Dear Sir/Madam,

HE's comments on the Relevant Representations

Highways England comments on Written Representations published on 16 January 2017

RIGHTS OF WAY AND ACCESS PLANS
REGULATION 5(2)(k) & 5(2)(o)
SHEET 3 OF 4

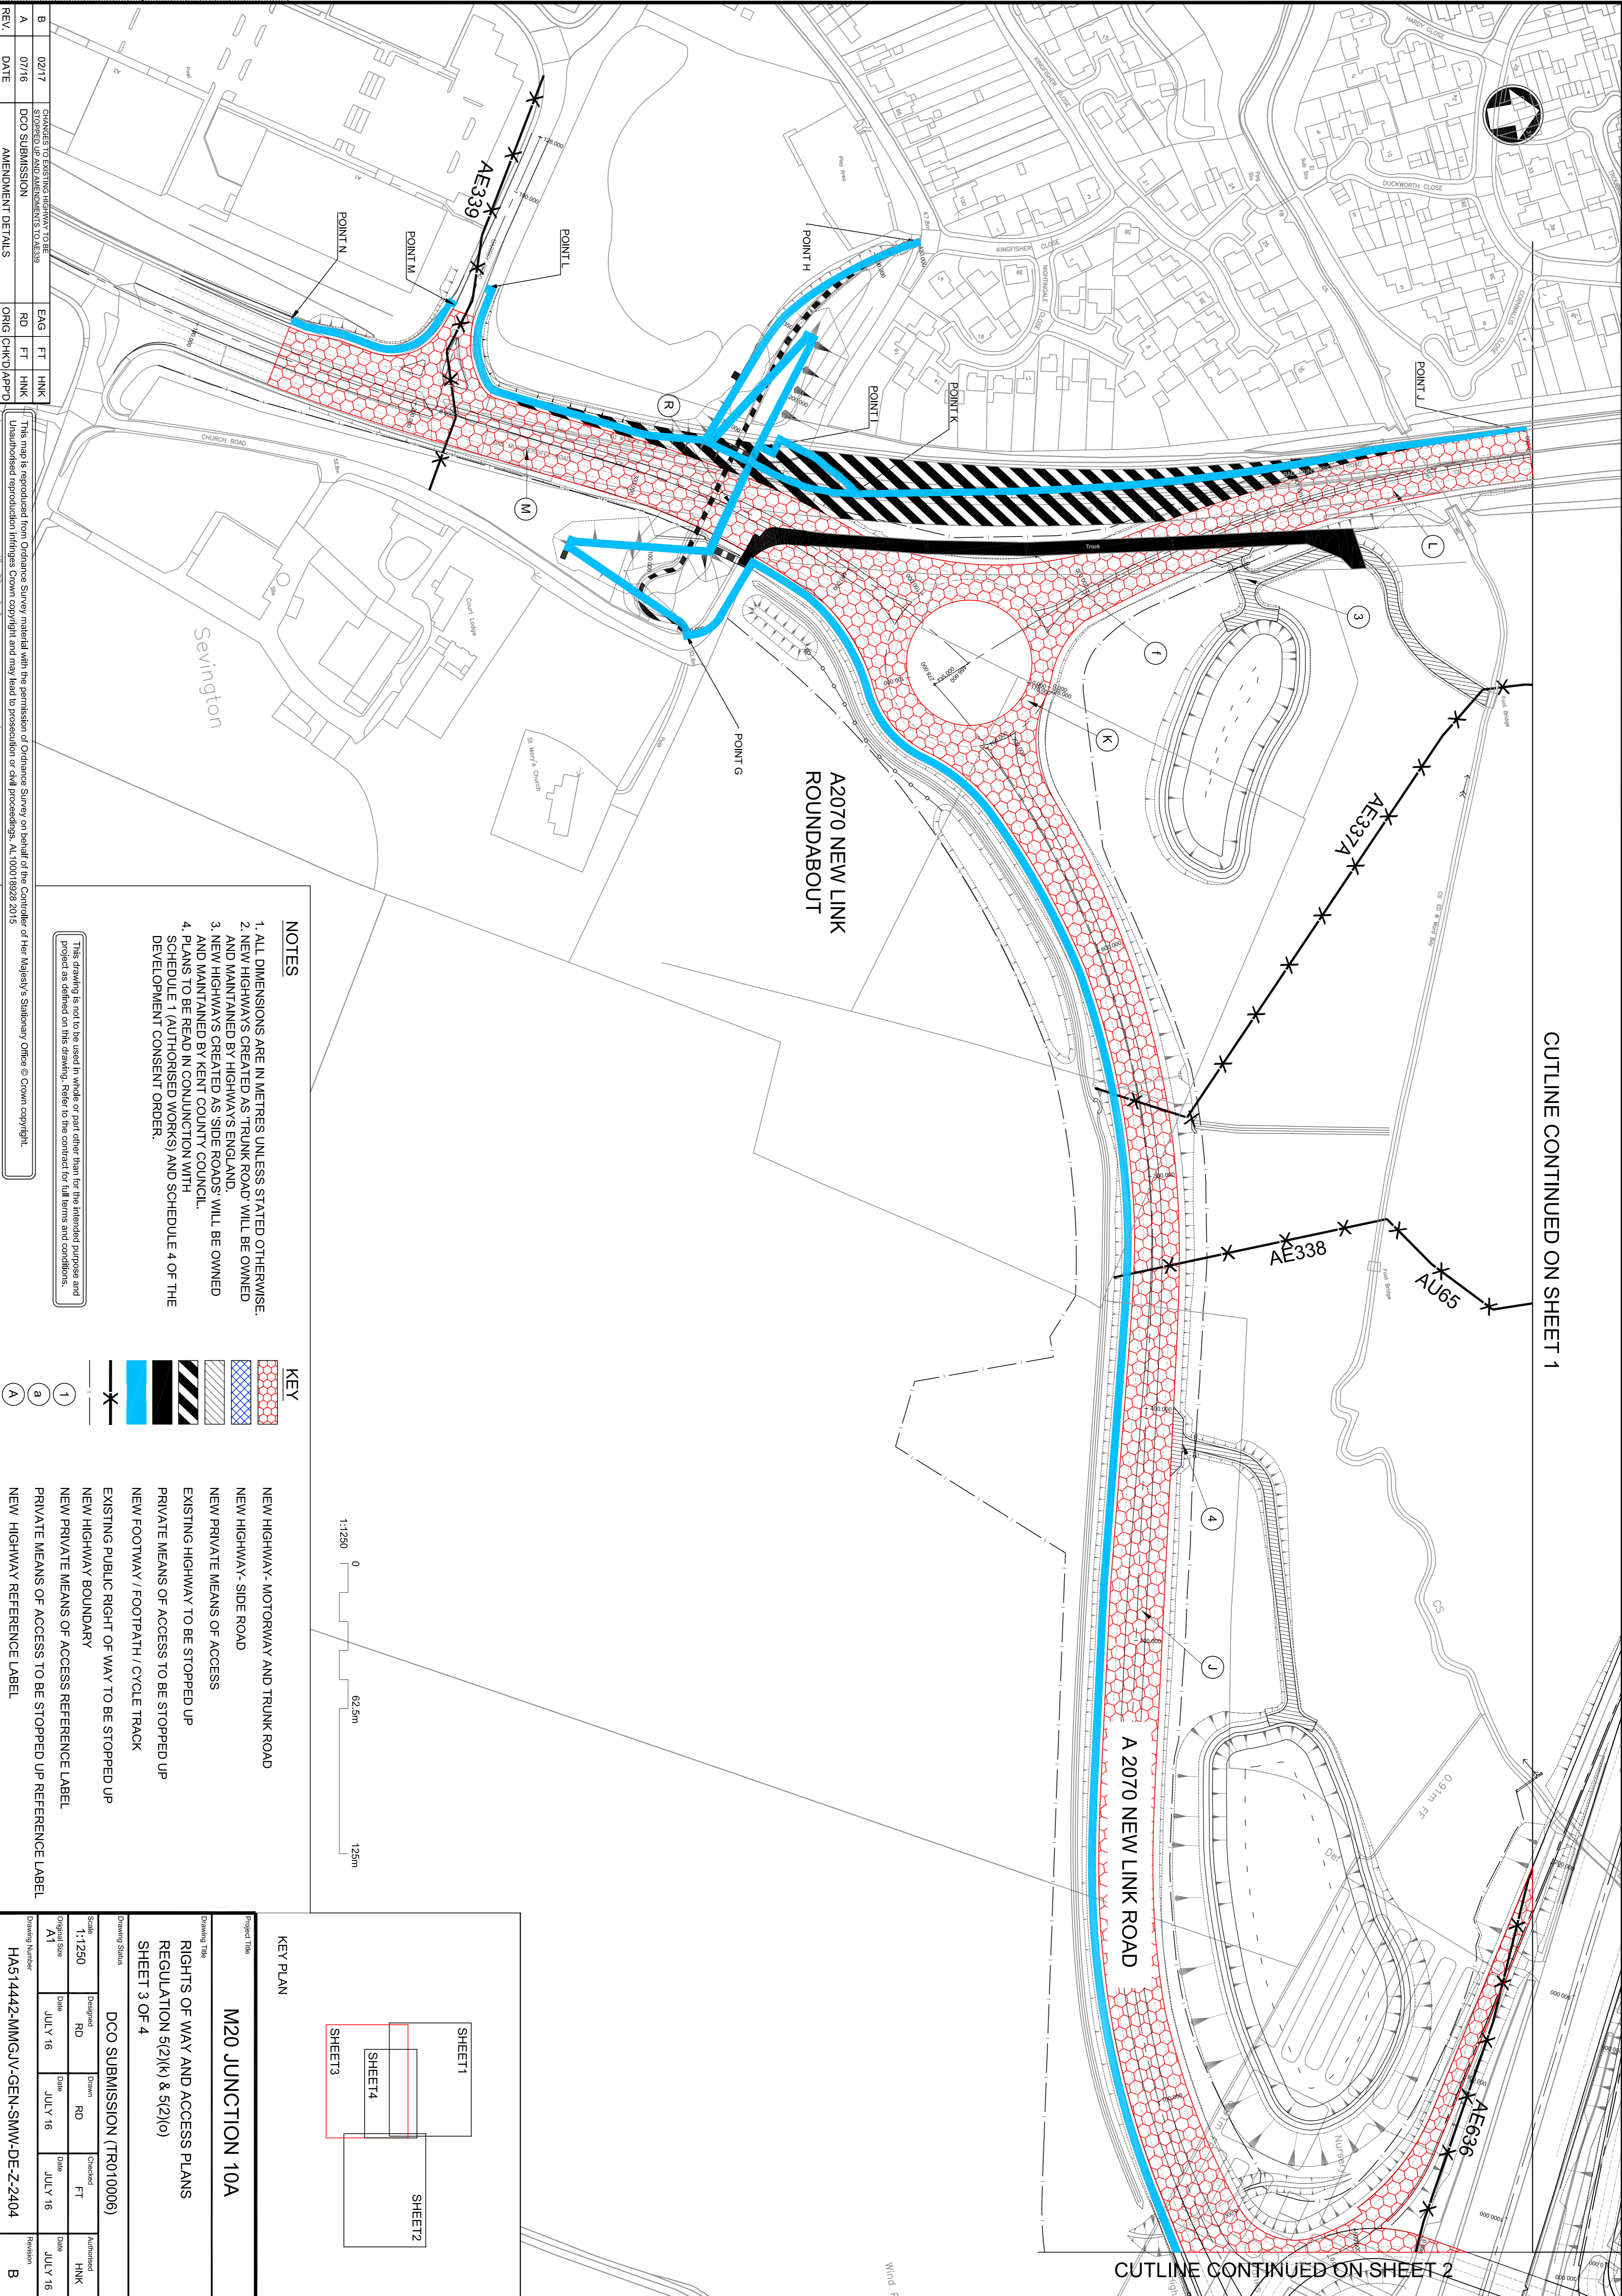
026.07 – Kingsford Street bridge should allow for equestrian traffic and be provided as part of the scheme.
